SSD-70283710: 1 Crescent Street, Holroyd

Transport Impact Assessment - Response to Submissions

14 November 2025

PROJECT	1 CRESCENT STREET, HOLROYD
TITLE	SWEPT PATH ANALYSIS - LOADING 11.8M RIGID VEHICLE

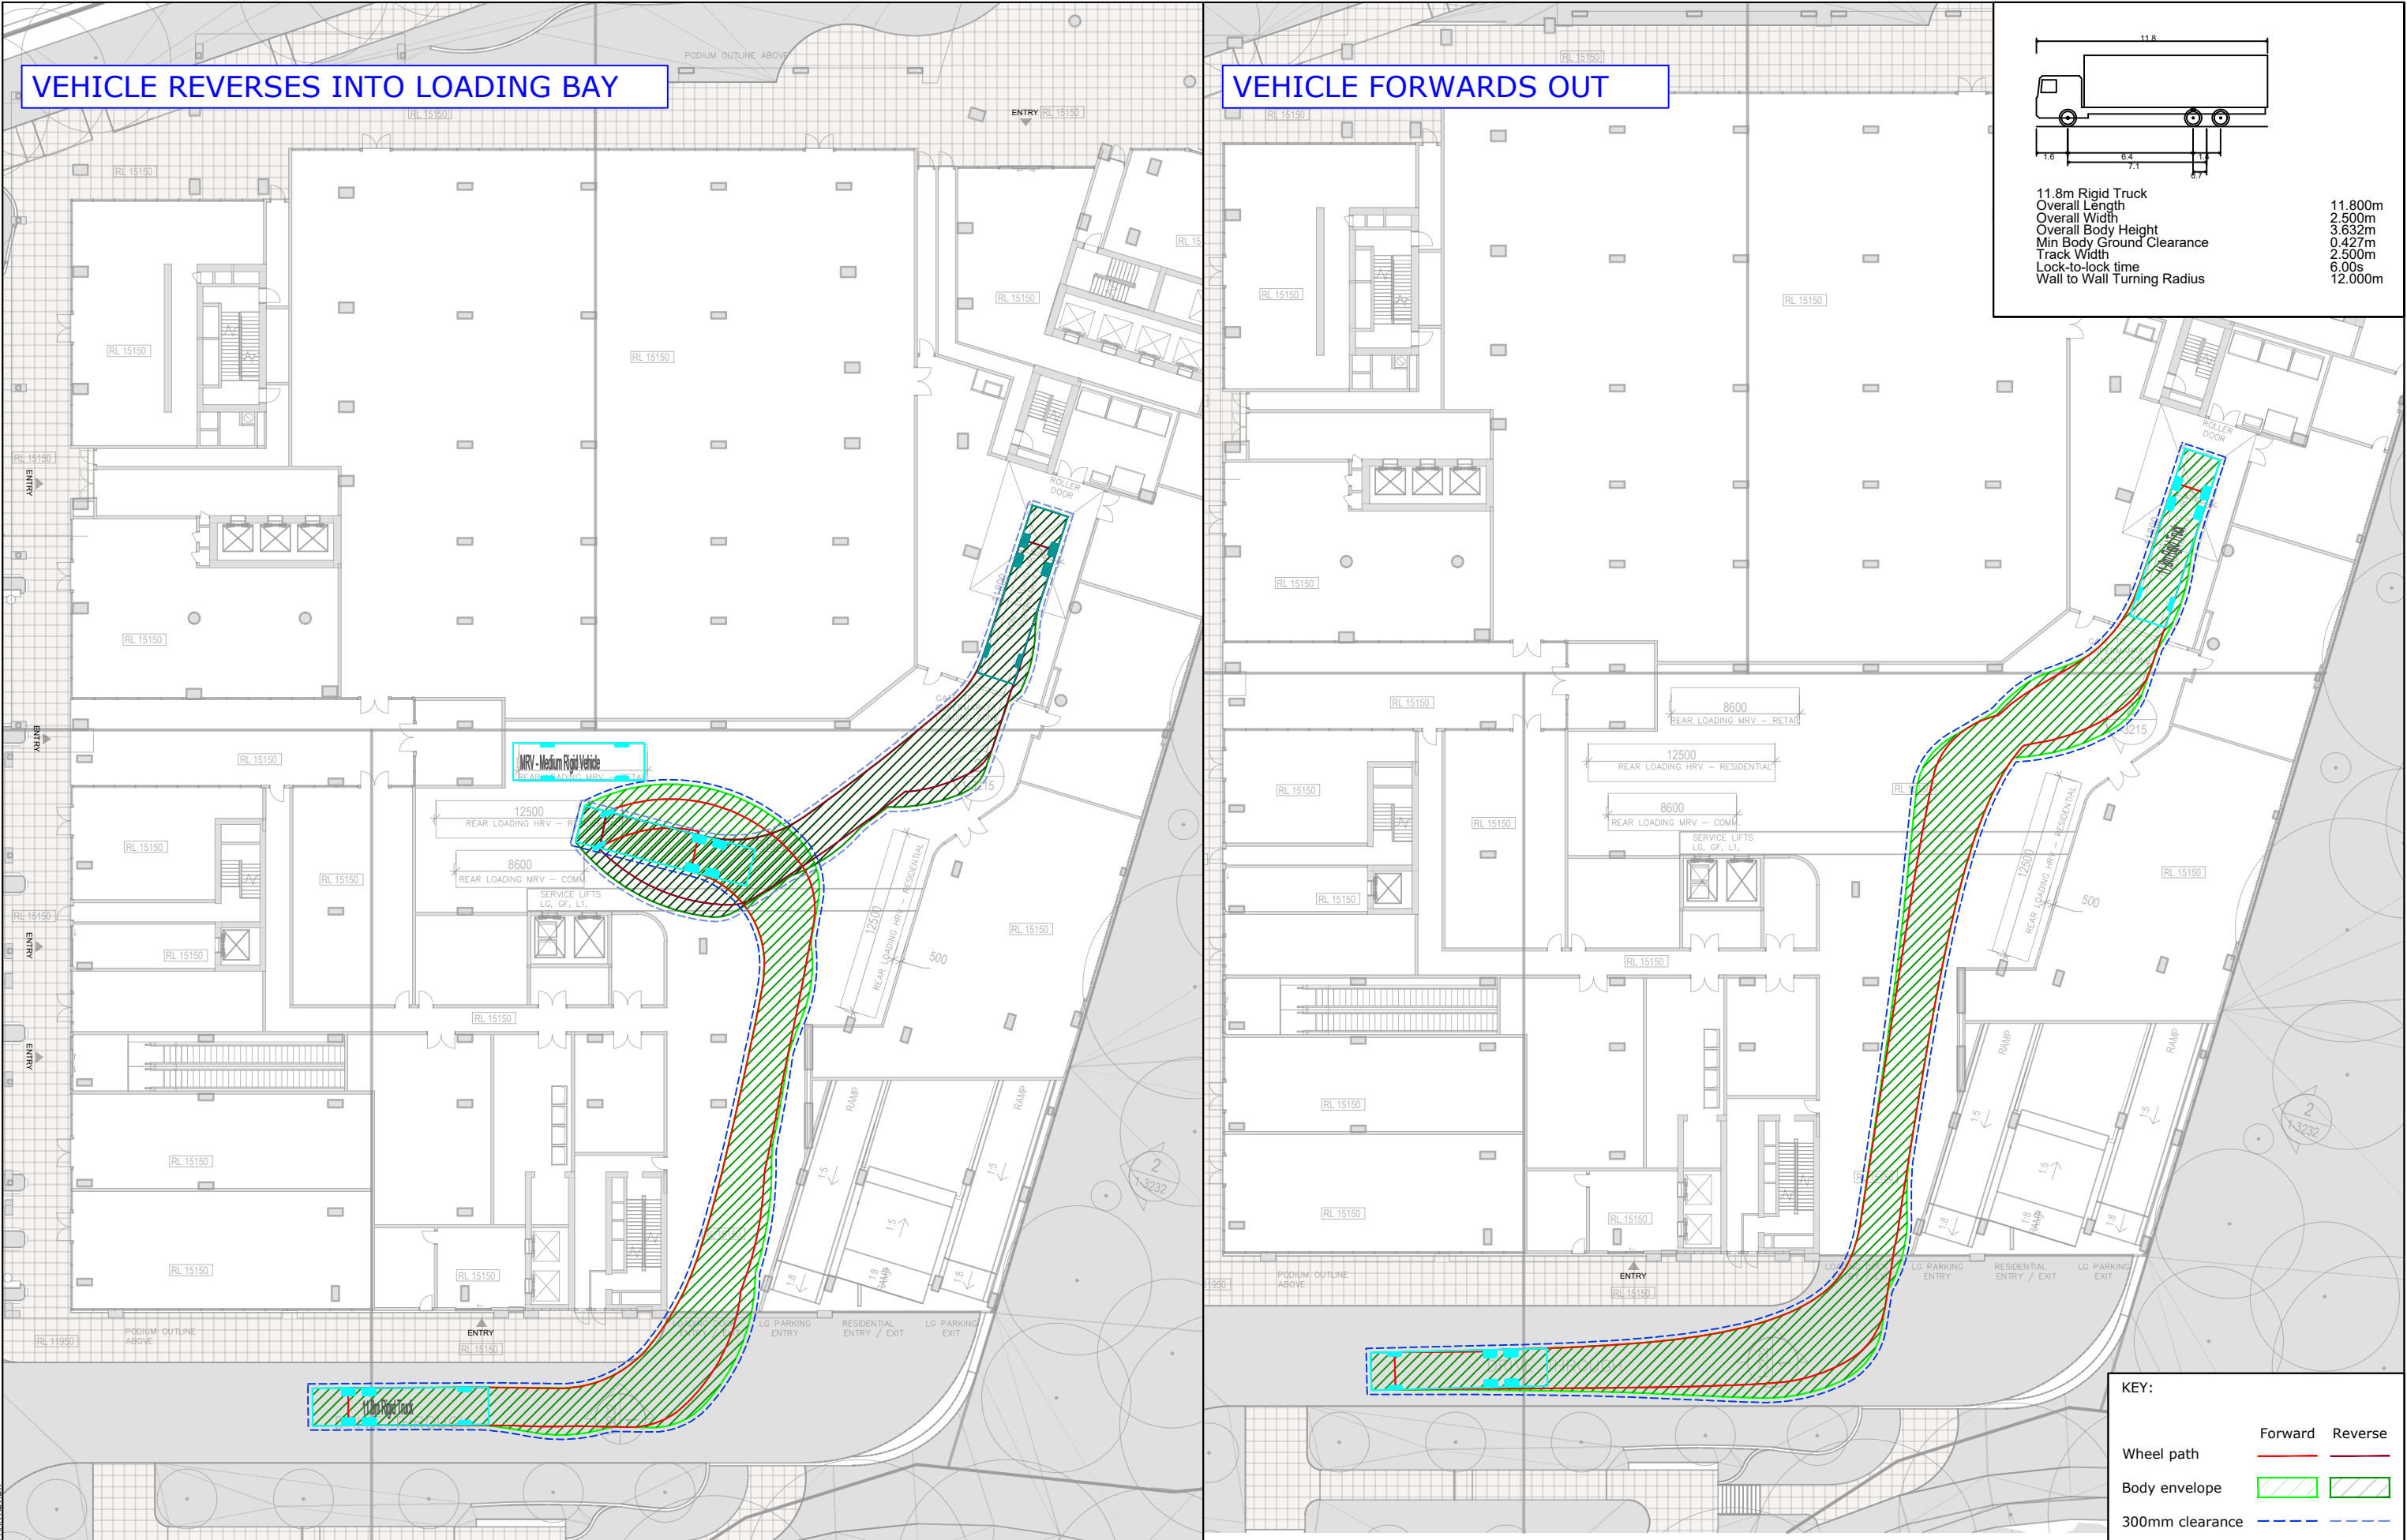
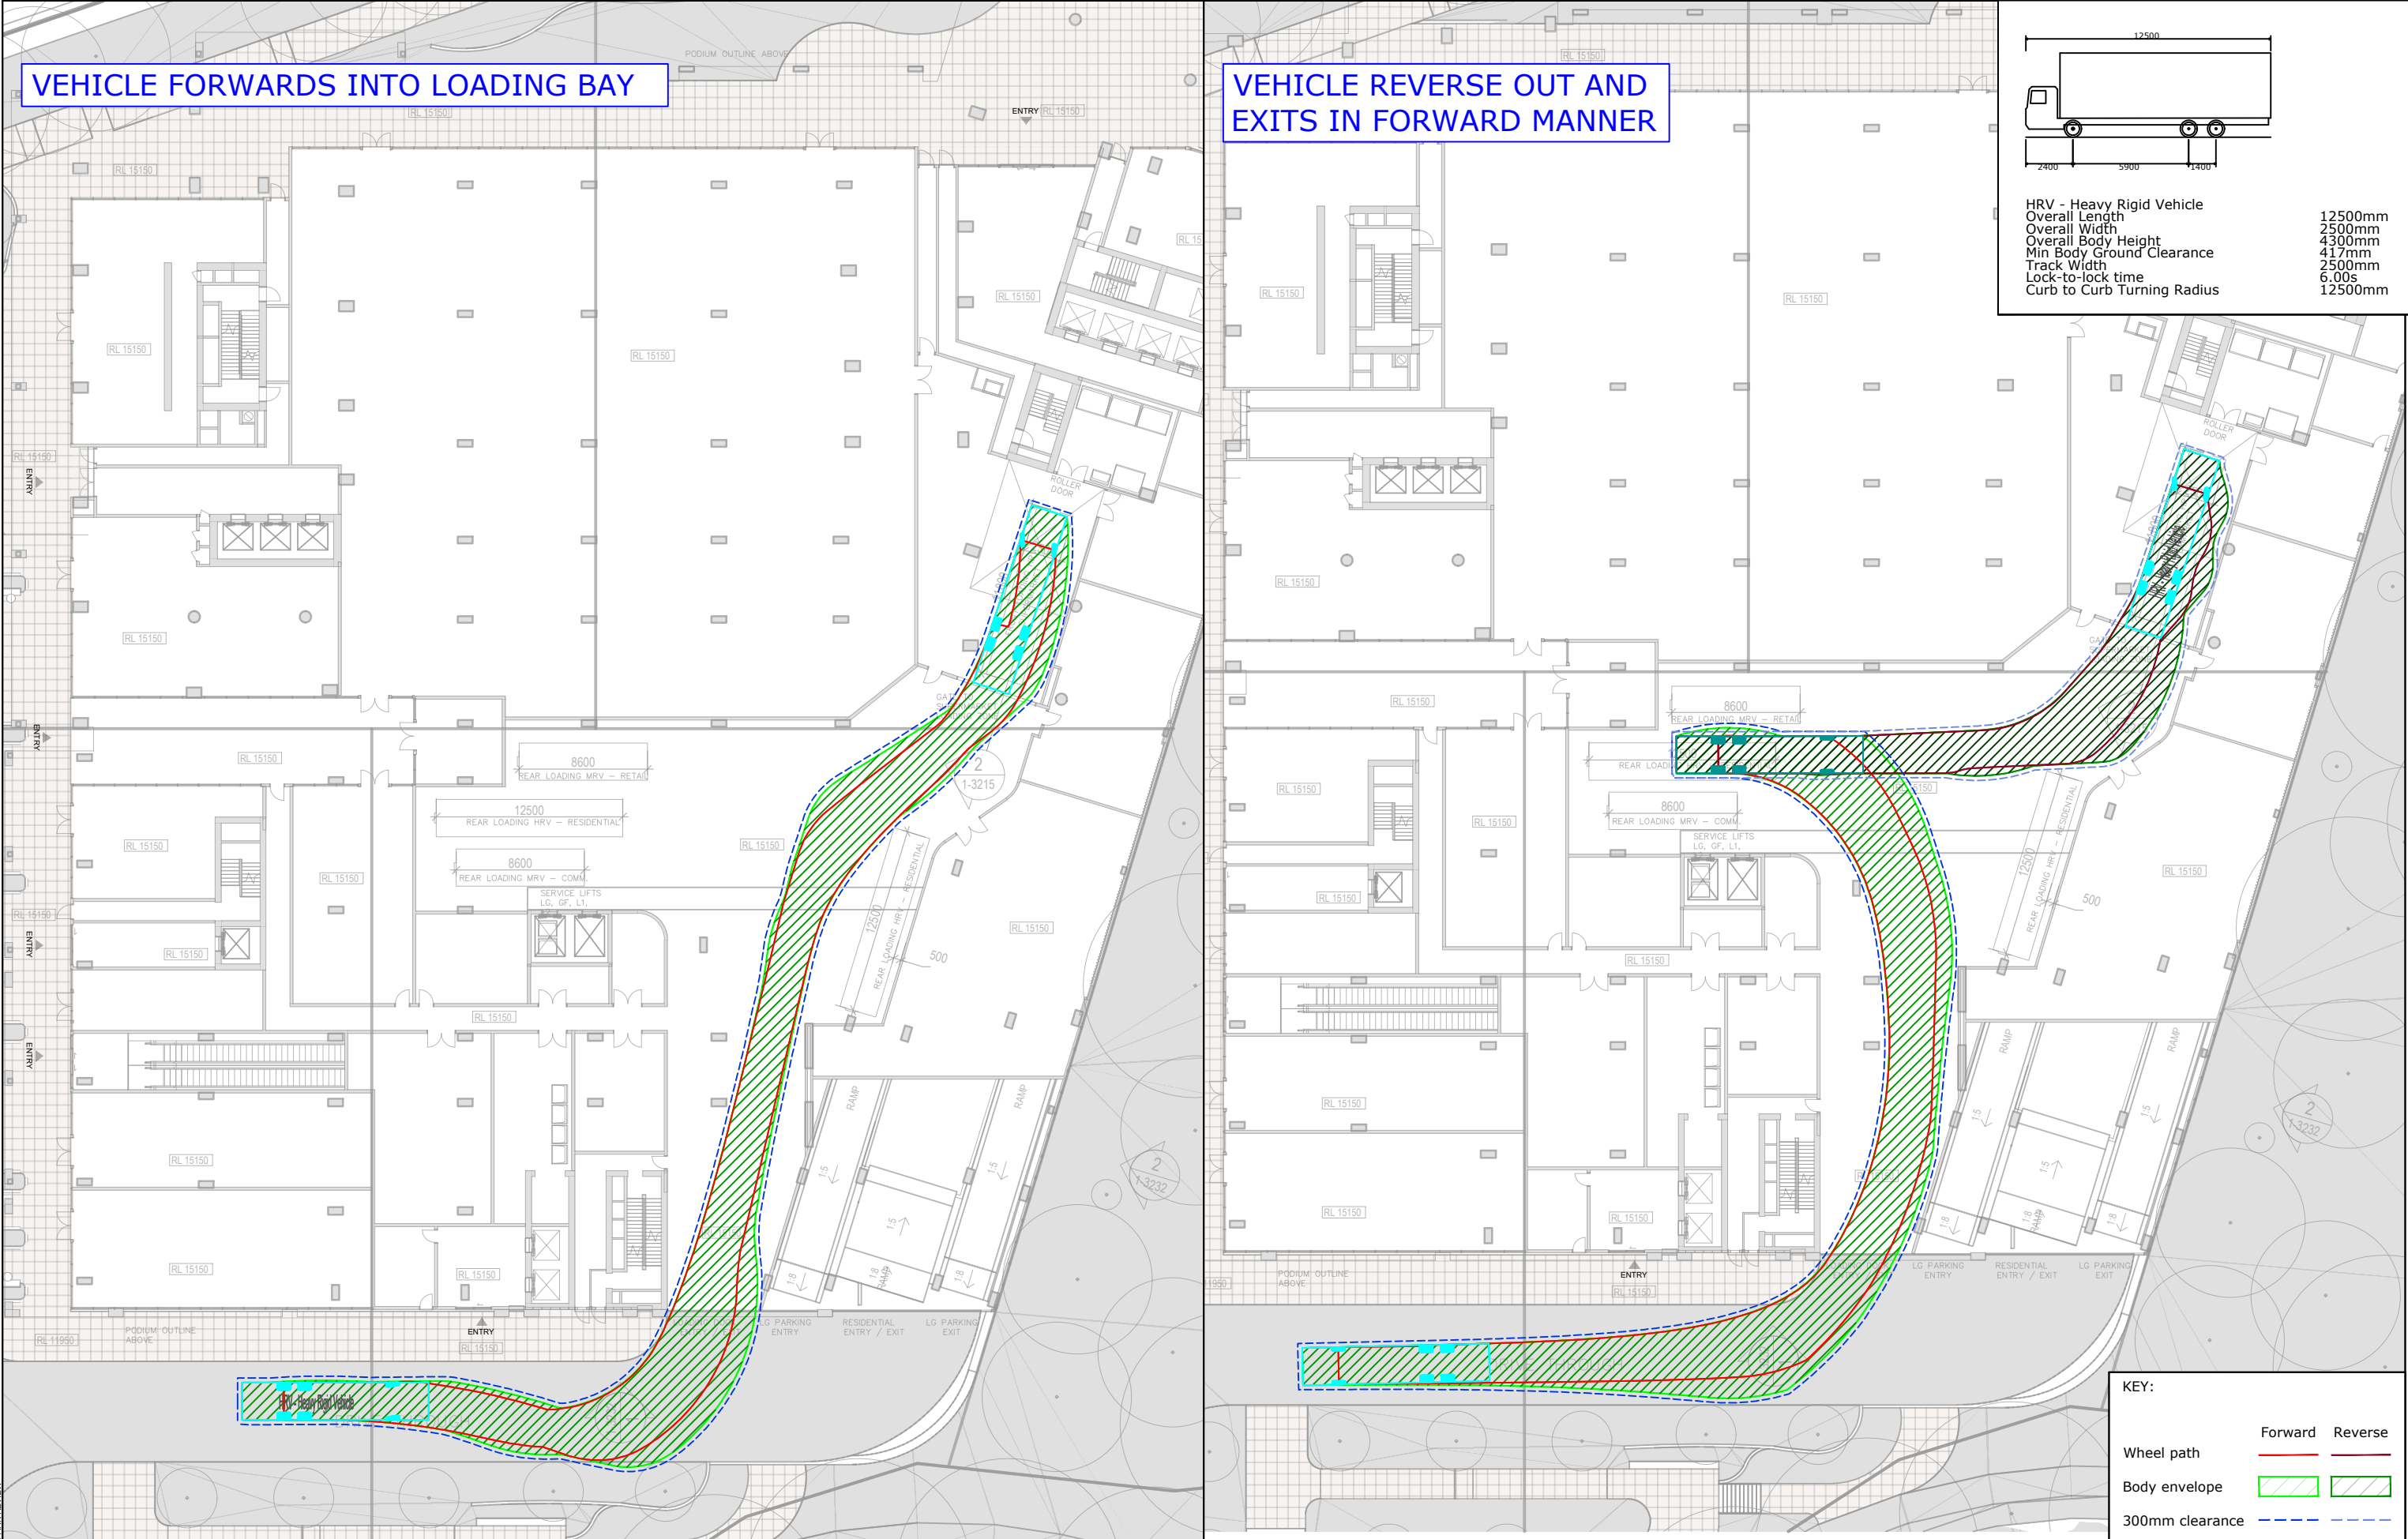
CC-9	Loading bays The 'general loading dock' appears to be deficient in area and detail to accommodate parking, loading and manoeuvring requirements for trucks required for the 2,500m ² of retail space and 5,000m ² of non-retail commercial space. If the general area is utilised by a number of trucks and a further truck then arrives in a forward direction, there appears to be deficient space for that truck to either turn and exit or enter a waiting phase while other truck/s manoeuvre out of the area (if at all possible). Creating a logjam of delivery vehicles and possibly	Loading bay has been redesigned and includes a turntable to manage movement of vehicles.	Section 5.4

DPHI-B-12	Provide further consideration to the space, access and manoeuvrability within the Building 1/2/3 loading dock, in particular:	Loading dock has been redesigned to include a vehicle turntable to allow access for trucks.	Section 5
DPHI-B-12-A	a) it is not possible for HRVs to exit from the (N/S oriented) 'front loading supermarket' and 'rear loading residential' spaces when the (E/W oriented) 'rear loading residential' HRV space is occupied	Loading dock has been redesigned to include a vehicle turntable to allow access for trucks.	Section 5
DPHI-B-12-B	b) swept path analysis of a vehicle entering/exiting the (E/W oriented) 'rear loading residential' HRV space has not been provided	Loading dock has been redesigned to include a vehicle turntable to allow access for trucks.	Section 5
